March 8, 2018

Subject: Final Development Plan for the Hyak Amended PUD (File Z-87-00002 & Z-93-00003) – Transmittal of Comments

RE: Hyak PUD Addendum

**DEVELOPMENT, STORMWATER AND
 PARKING PLAN - PARCEL D**

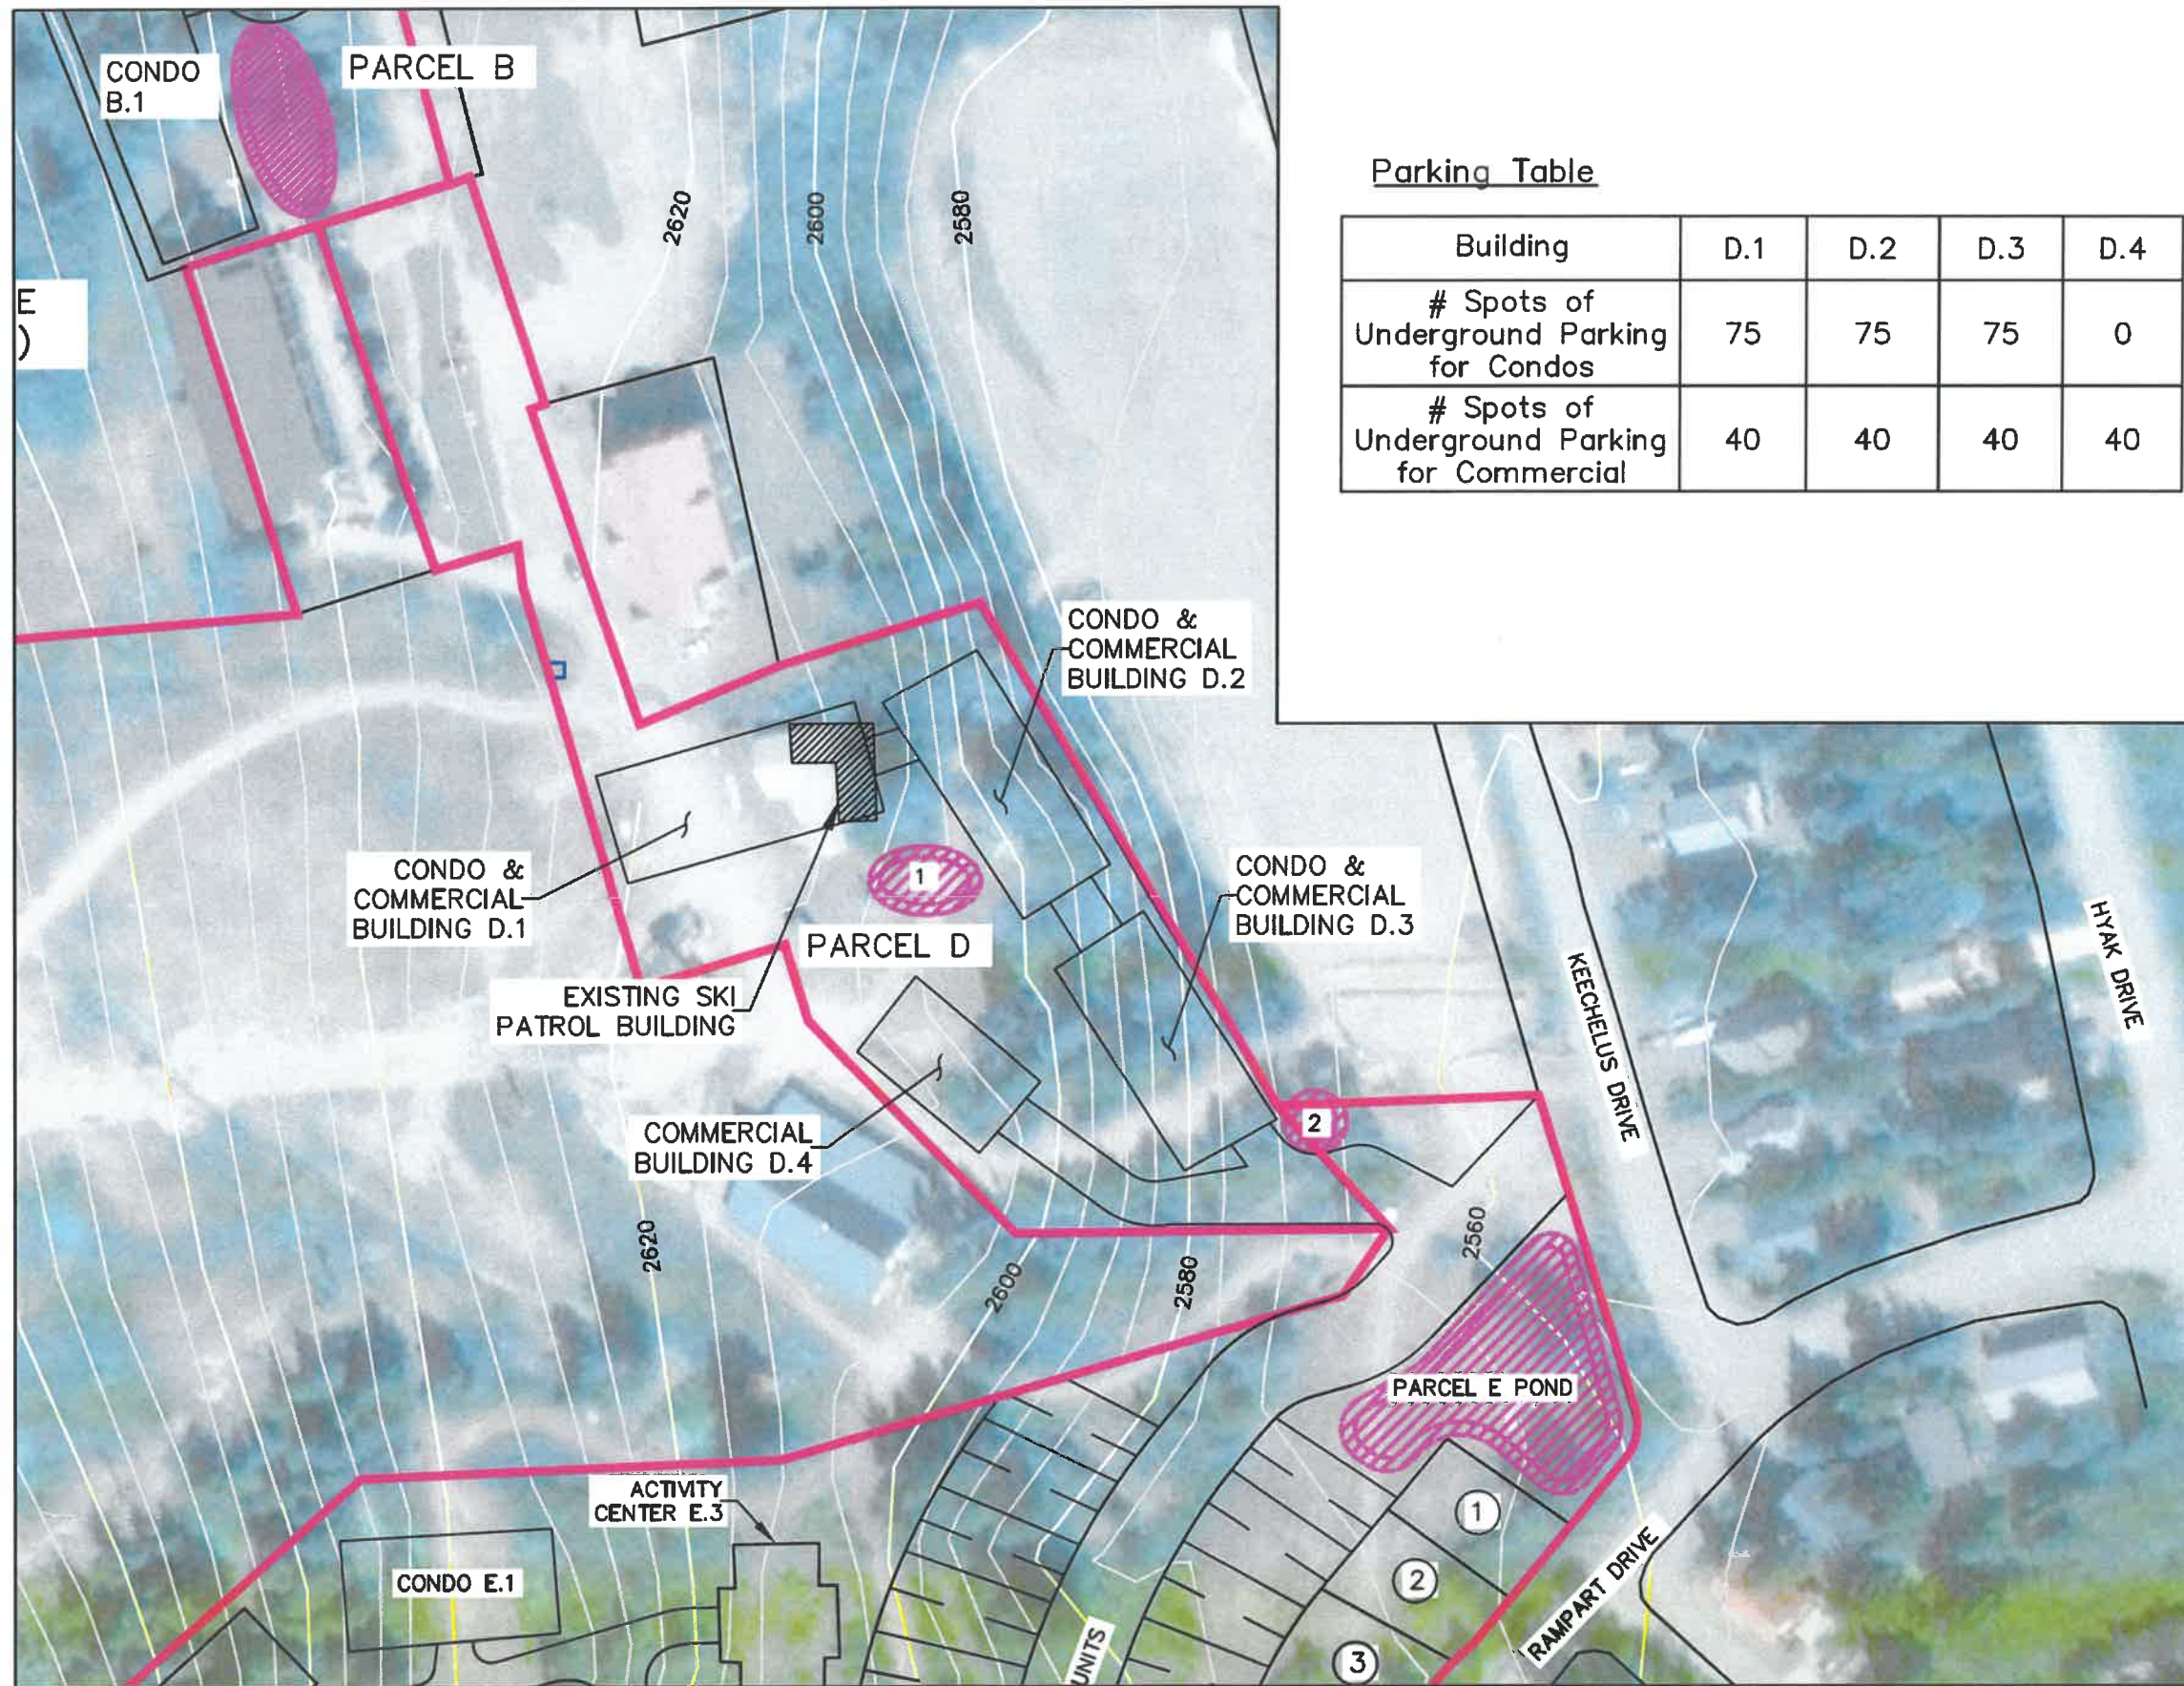
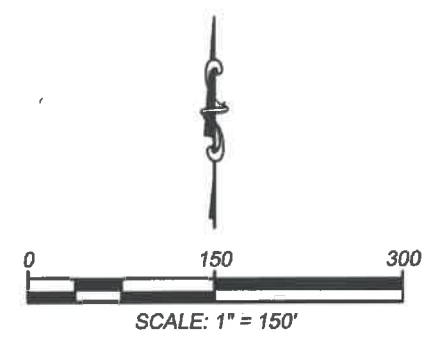
1. Several of the proposed stormwater ponds appear to span multiple contour intervals. The contour interval appears to be five feet. Please be advised that constructing the proposed ponds will likely impact developable land in the vicinity of the ponds. Public Works will assess the viability of pond construction on hill side slope at the time of civil engineering design submittal.

HYAK SNOW STORAGE EXHIBIT

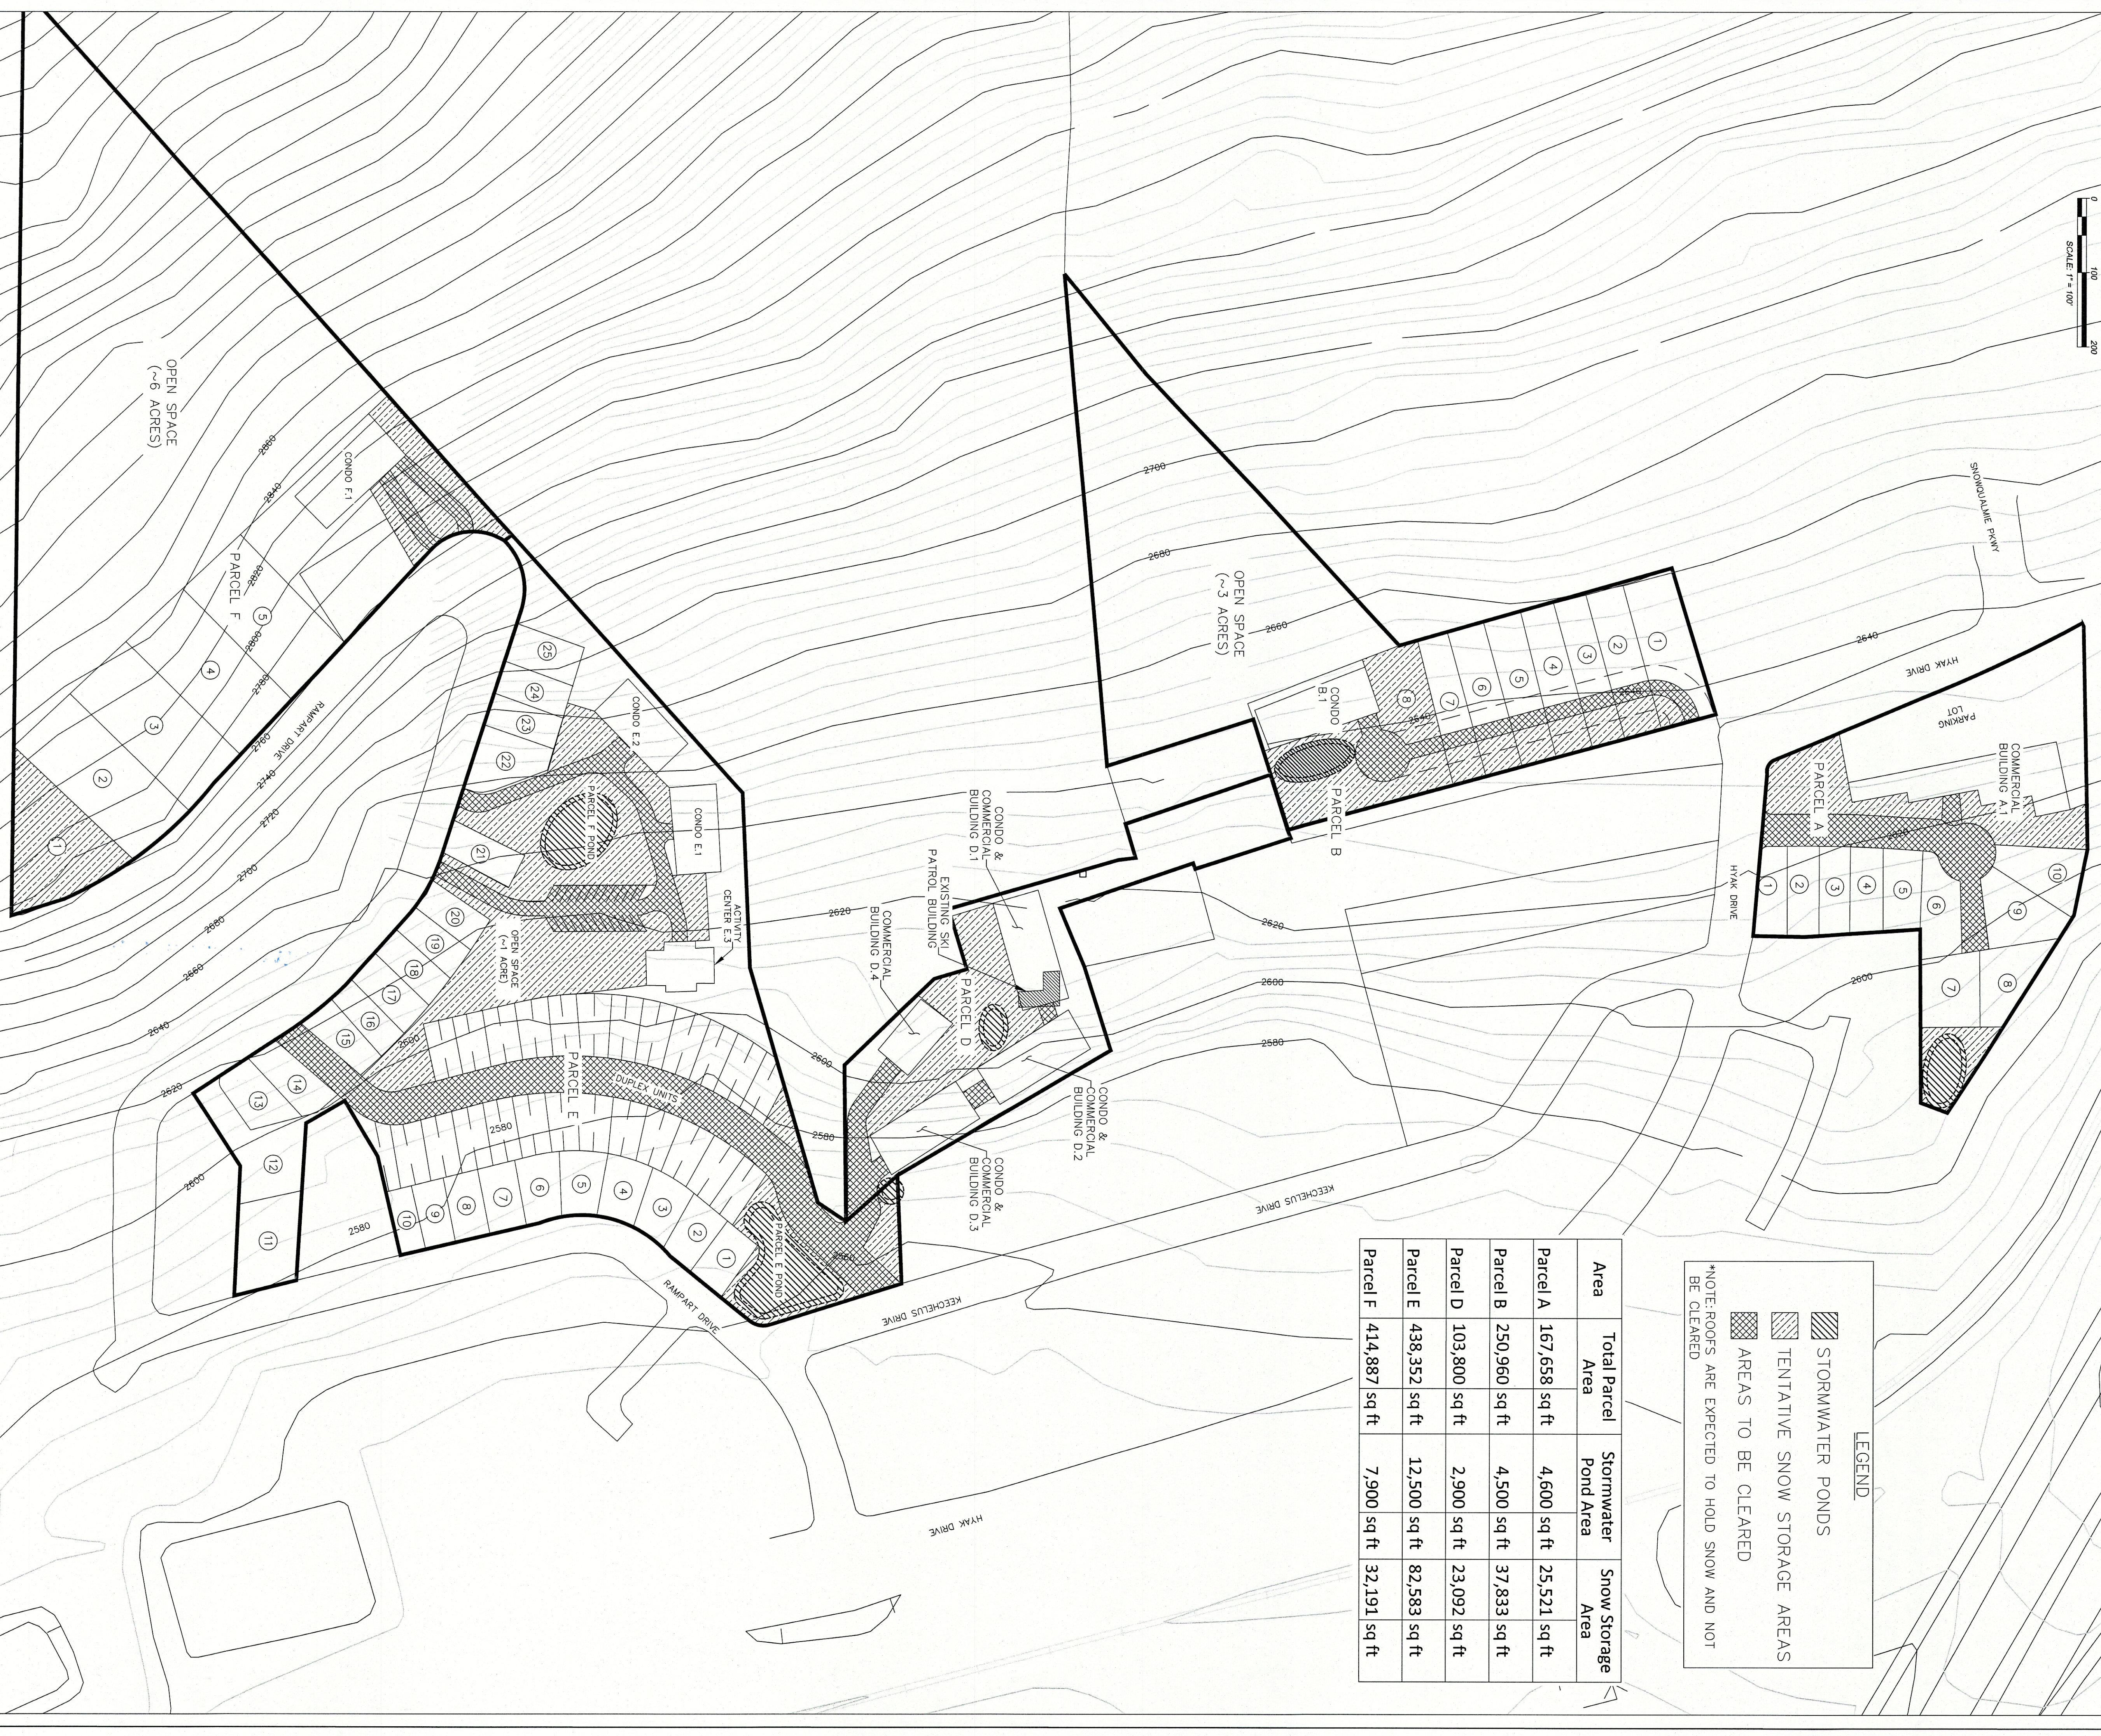
2. Proposed snow storage appears to be associated with new roadway construction, with the exception of Parcel F. If the extension of Rampart Drive is proposed to be constructed as a public roadway, the loss of downgradient parcels for snow storage will likely necessitate our petitioning the Board of County Commissioners for removing Rampart Drive from the public road network. The loss of snow storage could easily force Public Works to truck snow from Rampart Drive. We have been communicating our declining ability managing snow removal in Hyak as lots continue developing in the area. The applicant is encouraged to develop snow storage areas knowing the increasing likelihood of eventual county abandonment and reliance on private snow removal service providers.
